1. SSD10421 – Proposed Weigall Sports Complex – Response to Traffic Engineering Submissions

We have prepared this letter to address comments relating to parking and traffic engineering received from Woollahra Municipal Council, City of Sydney Council and the Department of Planning, Industry and Environment in relation to the subject projects.

Drawing Title
BUILDING 02
CAR PARK
GENERAL ARRANGEMENT PLAN
LOWER/UPPER GROUND
Sheet Status
NOT FOR CONSTRUCTION

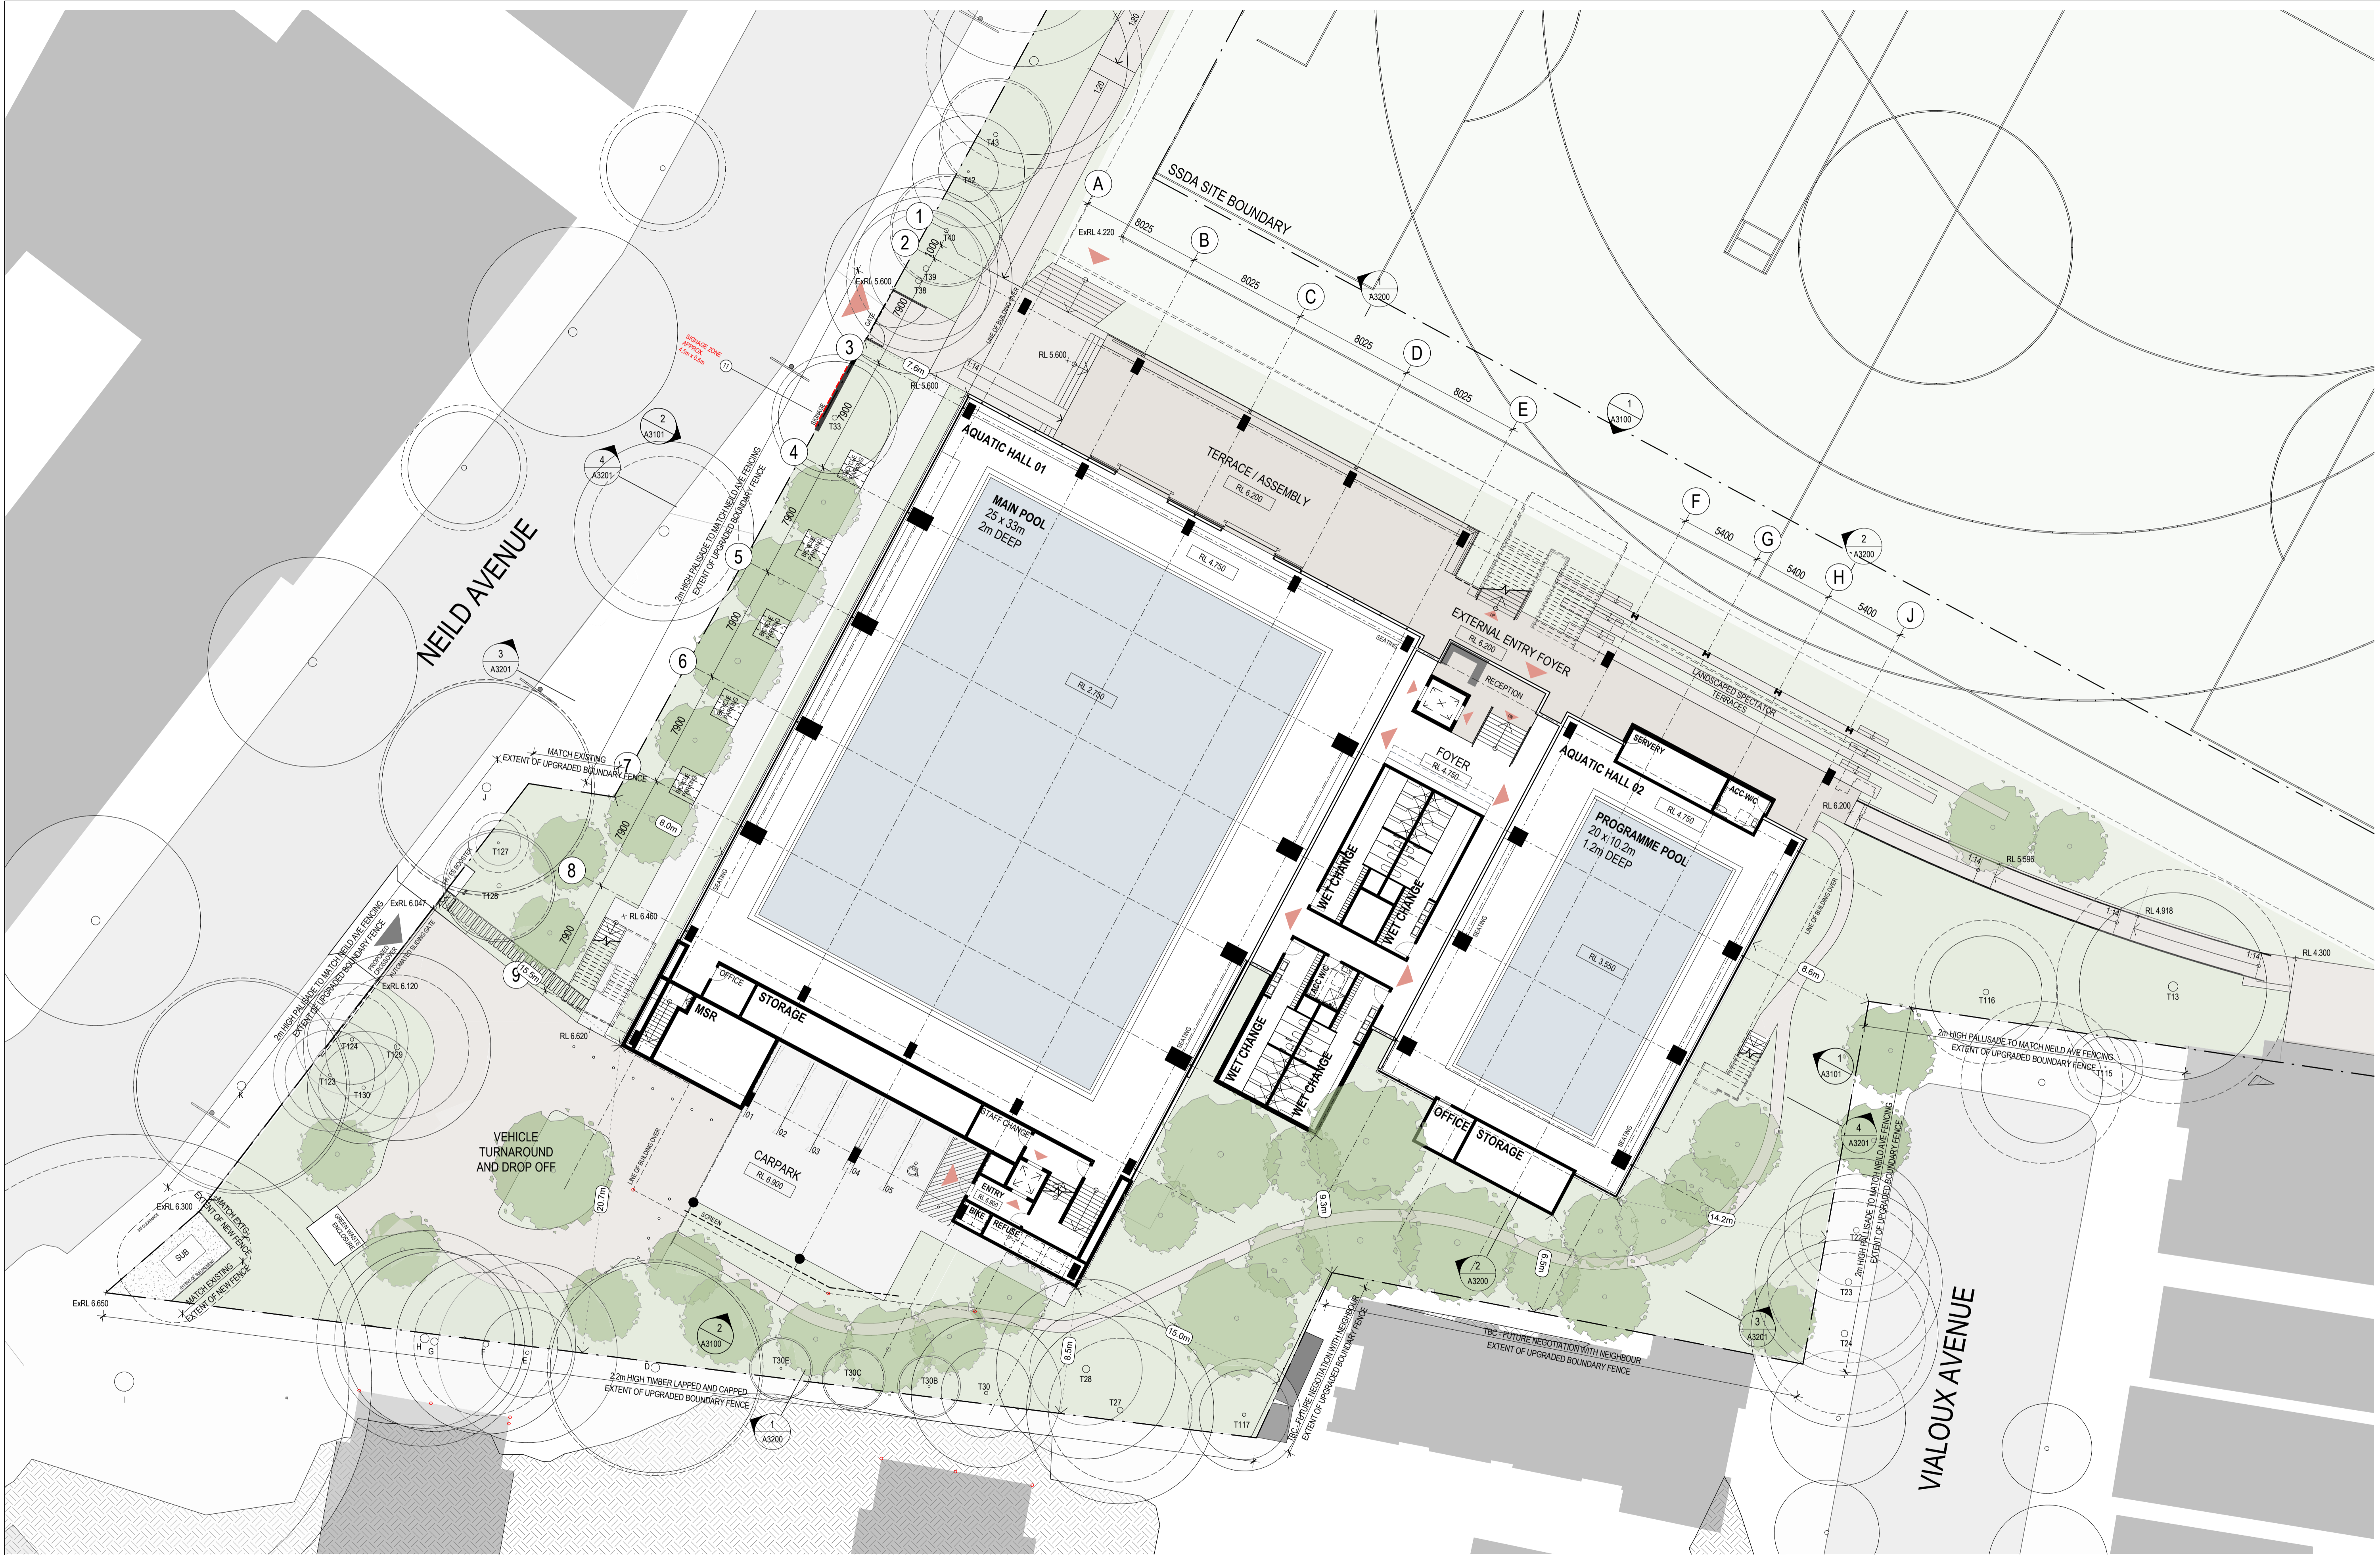
3) It is understood that community use of the proposed facilities remain unclear, and that these users would not have access to car park in Building 2/Car Park Building. It should be noted that these users will require parking spaces, and without on-site provision, an increased demand for kerbside parking would occur. Traffic Section raises concerns on these parking demand in the surrounding area, where high occupancy rate of parking spaces are witnessed.

It is noticed that small car and accessible parking spaces are proposed. Further assessment will be made upon revised parking analysis. It should be noted that, small car parking spaces must not exceed 5% of the overall number of parking spaces, as per E1.9.6 of Council's DCP, and provision of accessible park should comply with D3.5 of Building Code of Australia.

The car park will accommodate 102 parking spaces including two accessible spaces.

Three small parking spaces are proposed, which represents 3% of the total provision.
